State of Washington
DEPARTMENT OF FISH AND WILDLIFE

February 10, 2025

SUBJECT: WDFW COMMENTS ON PARKE CREEK LANDING PLANNED UNIT DEVELOPMENT (PD-24-00002, PLAT LP-24-00004, SEPA SE-25-00001)

SITE DEVELOPMENT PLAN - PARKE CREEK LANDING  
A PORTION OF THE NW 1/4 & A PORTION OF THE SW 1/4 OF SECTION 34, T. 18 N., R. 20 E., W.M.  
KITITAS COUNTY, STATE OF WASHINGTON

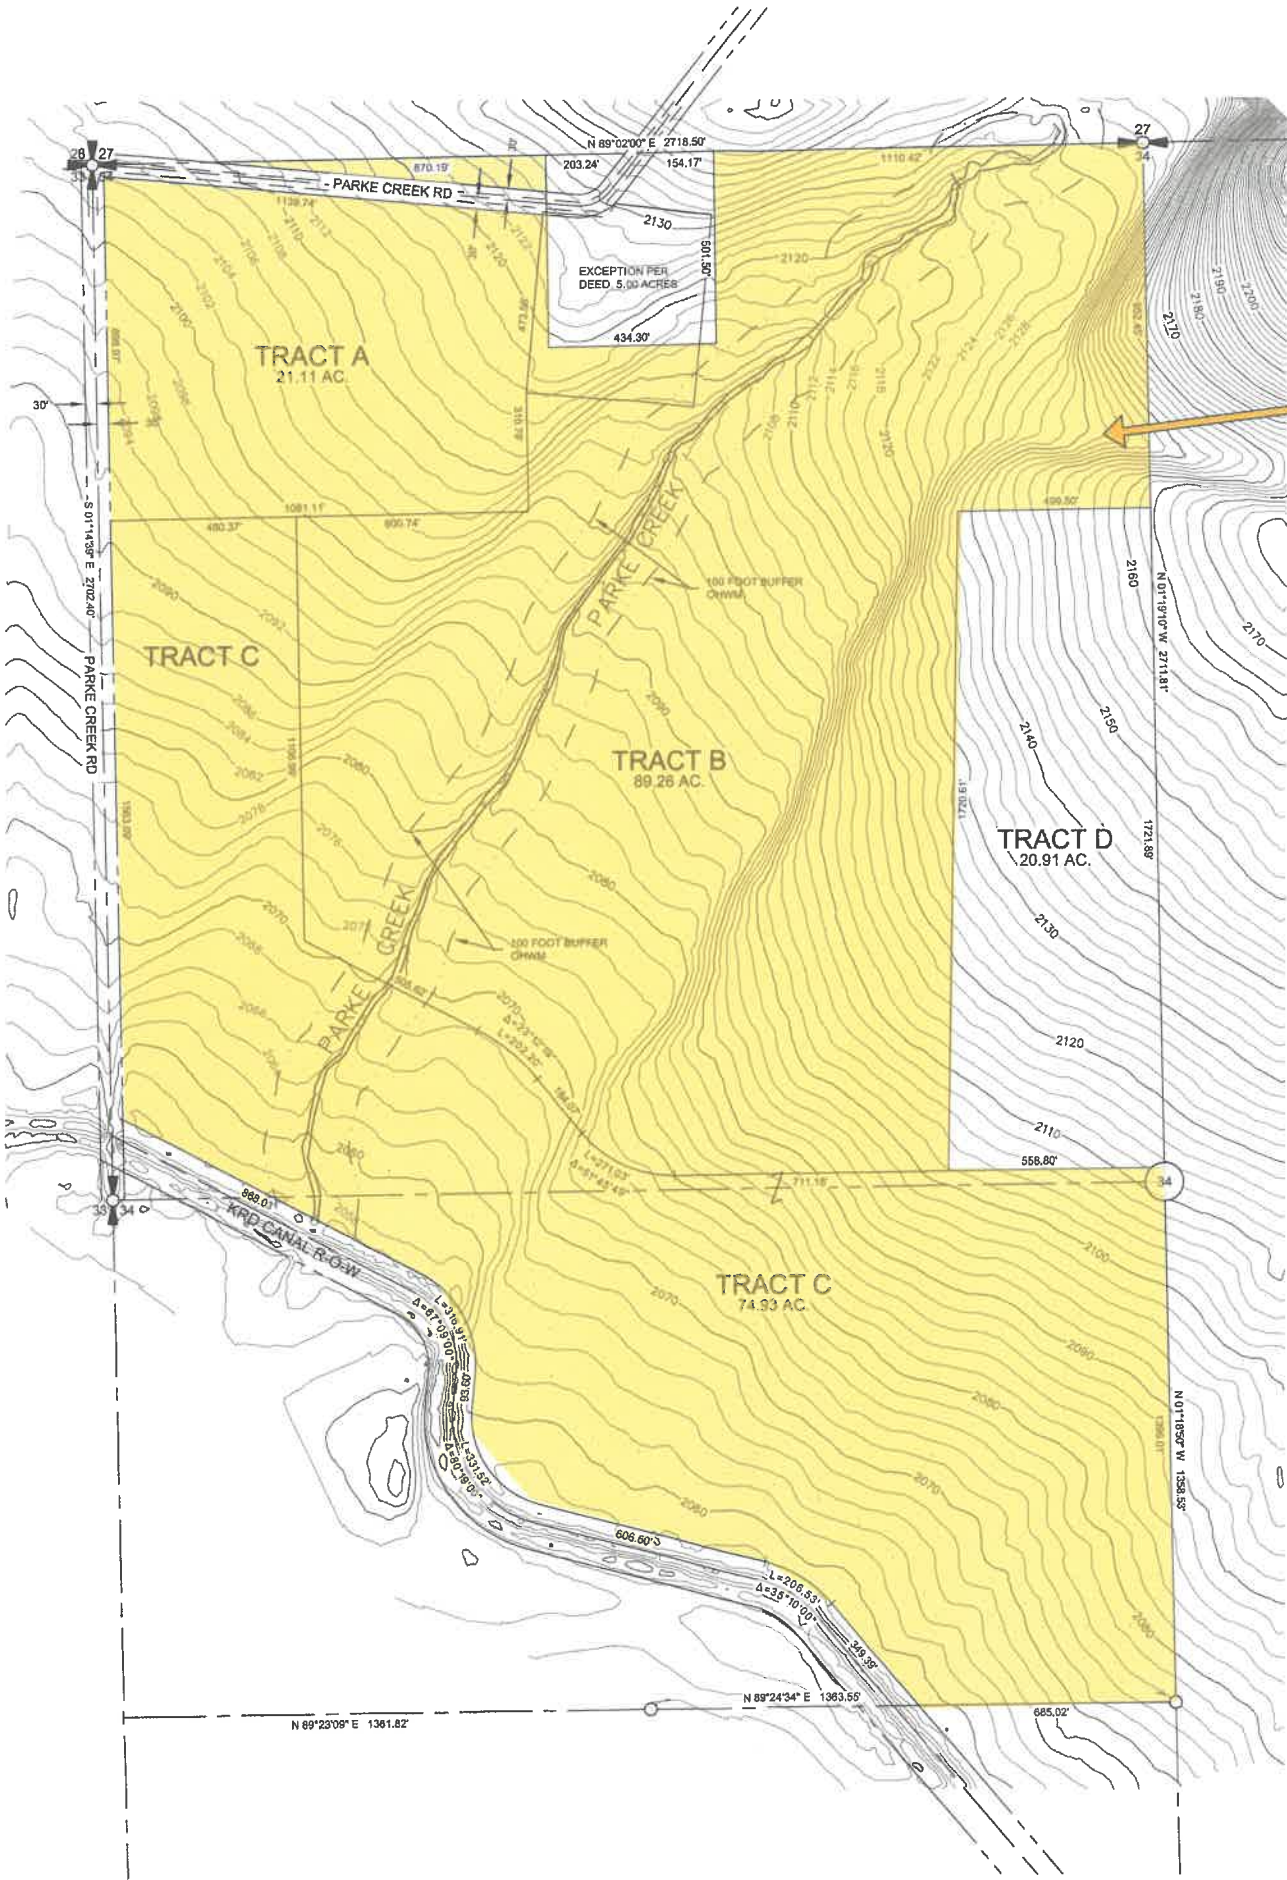
The materials available for review discuss the removal of most of the shrubs within the intact shrubsteppe portion of the project, where the Outdoor Recreation Area will be built. Several places within the application dismisses this shrubsteppe habitat as non-important and as not fitting in with the surrounding land uses. WDFW strongly disagrees with these statements. **We look forward to better understanding the details for the proposed project, including what is**

planned for Tract D, and collaborating on a path forward that will adequately mitigate for all potential impacts to all critical areas onsite.
